Our Reference: SYD17/01651\_2 & SYD17/01653\_2  
Your Ref: SSD8925 & SSD8925

**PROPOSED NEW SYDNEY FISH MARKET  
STAGE 1 CONCEPT WORKS AND STAGE 2 MAIN WORKS  
1A TO 1C BRIDGE RD, GLEBE & PART 56-60 PYRMONT BRIDGE ROAD, PYRMONT**

Roads and Maritime has reviewed the submitted application does not provide concurrence for the proposed development application. The following additional information shall be provided:

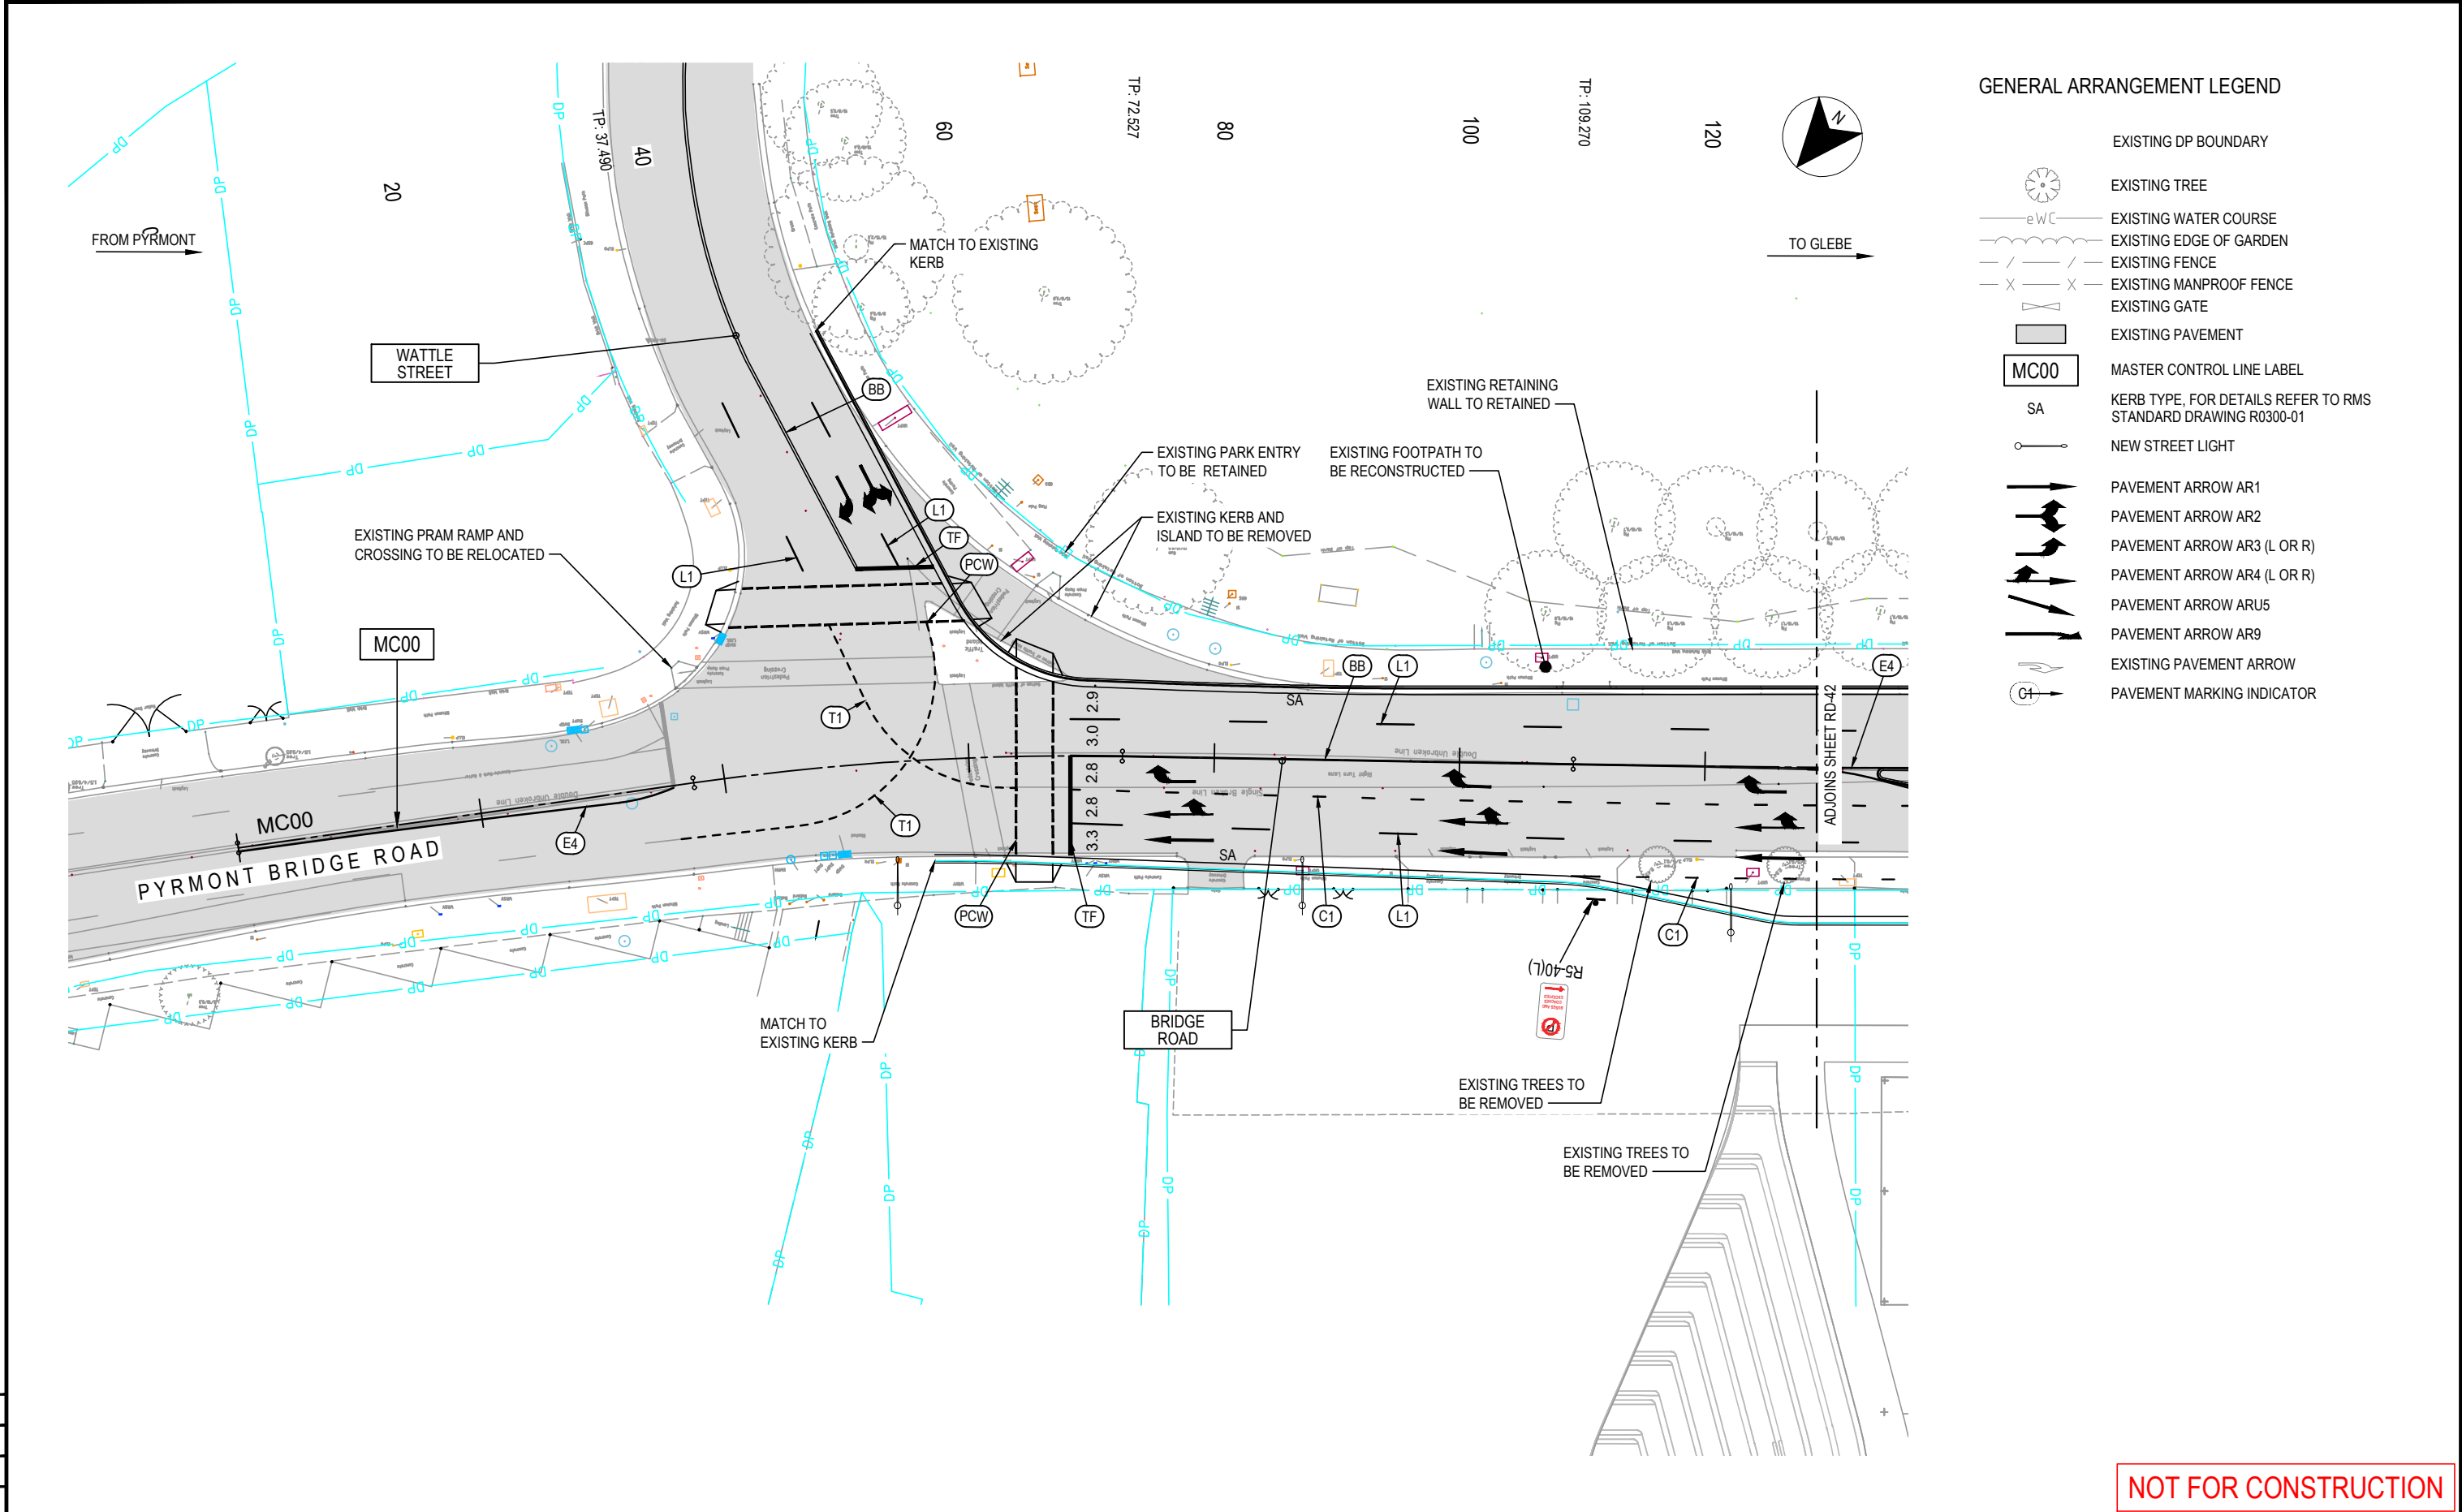
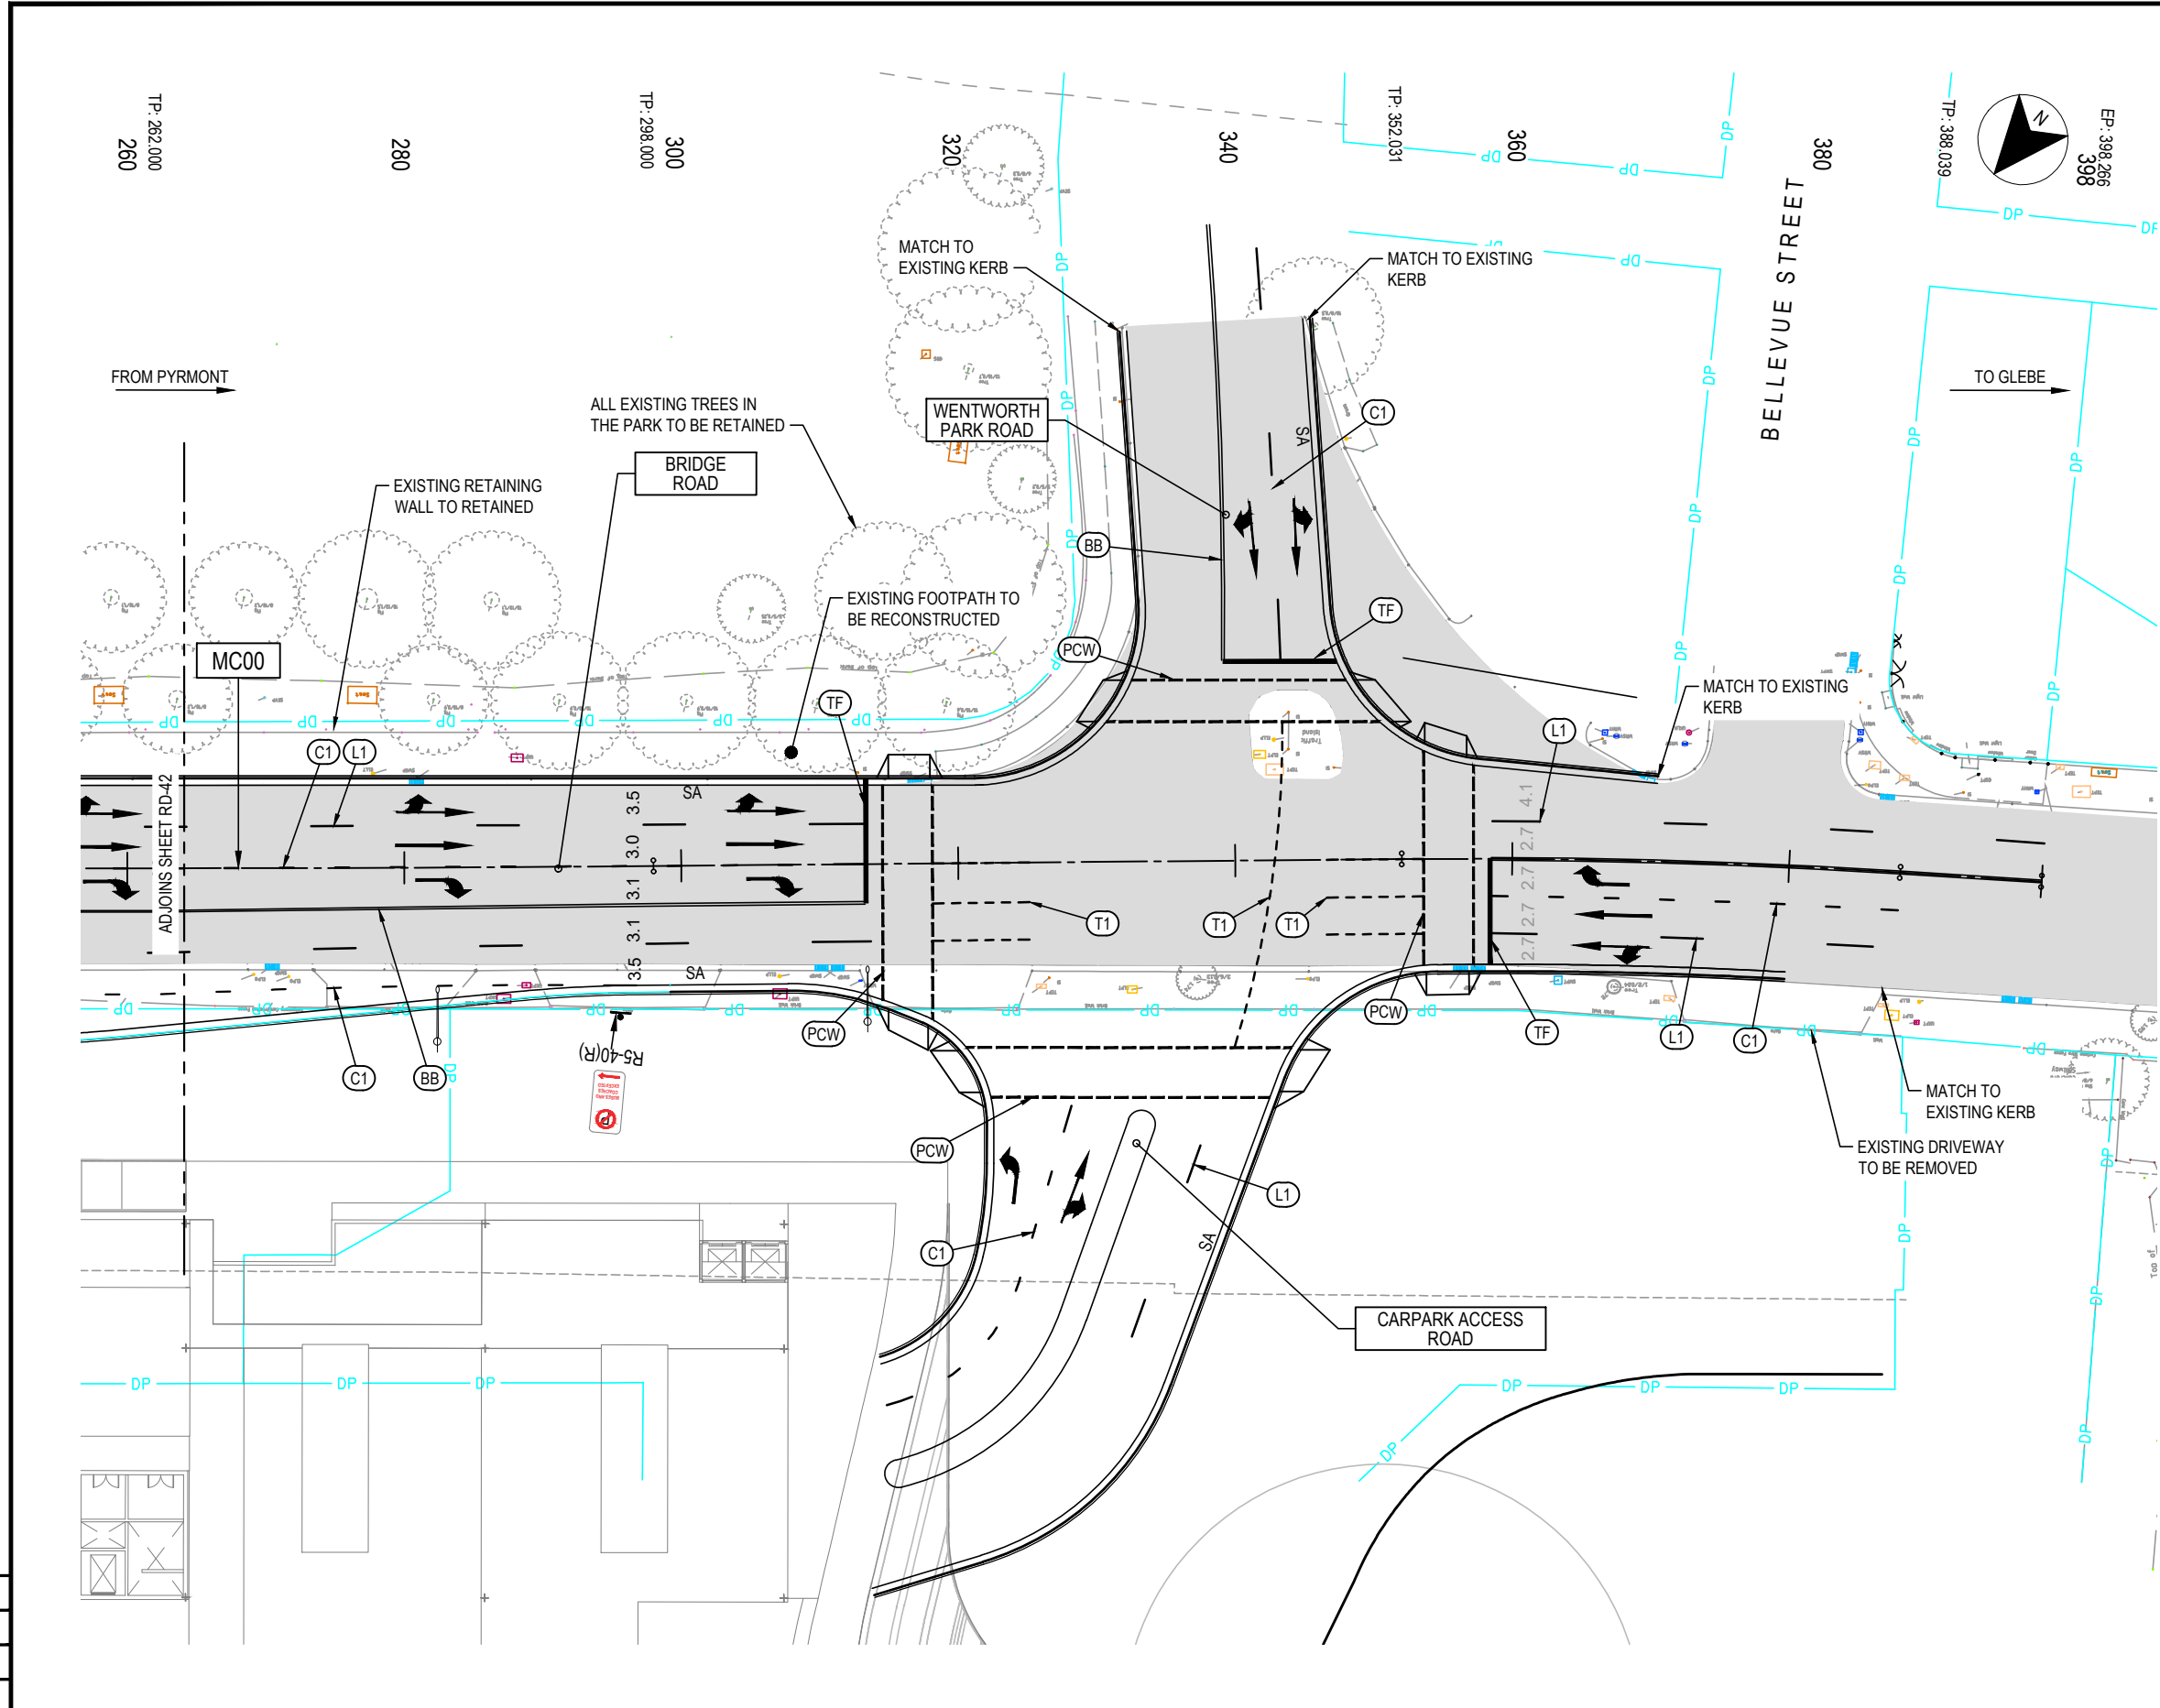
5. While pedestrian amenity will be improved, the installation of a marked foot crossing on the eastern approach of Bridge Road along with the removal of the slip lane from Wattle Street will result in delays for all vehicles coming from Wattle Road due to the requirement for full pedestrian protection. An exemption of this pedestrian leg should be sought or use of flashing amber arrows used to increase traffic flow.

6. Additional justification shall be provided for the removal of the left turn slip lane at TCS1200 considering the high importance of this section to the network.

9. Pedestrian protection shall be provided for the dual right turns from Wattle Street into Bridge Road (TCS1200). The new pedestrian crossing at the northern approach of Pymont Bridge Road will also need to be reflected in the modelling.
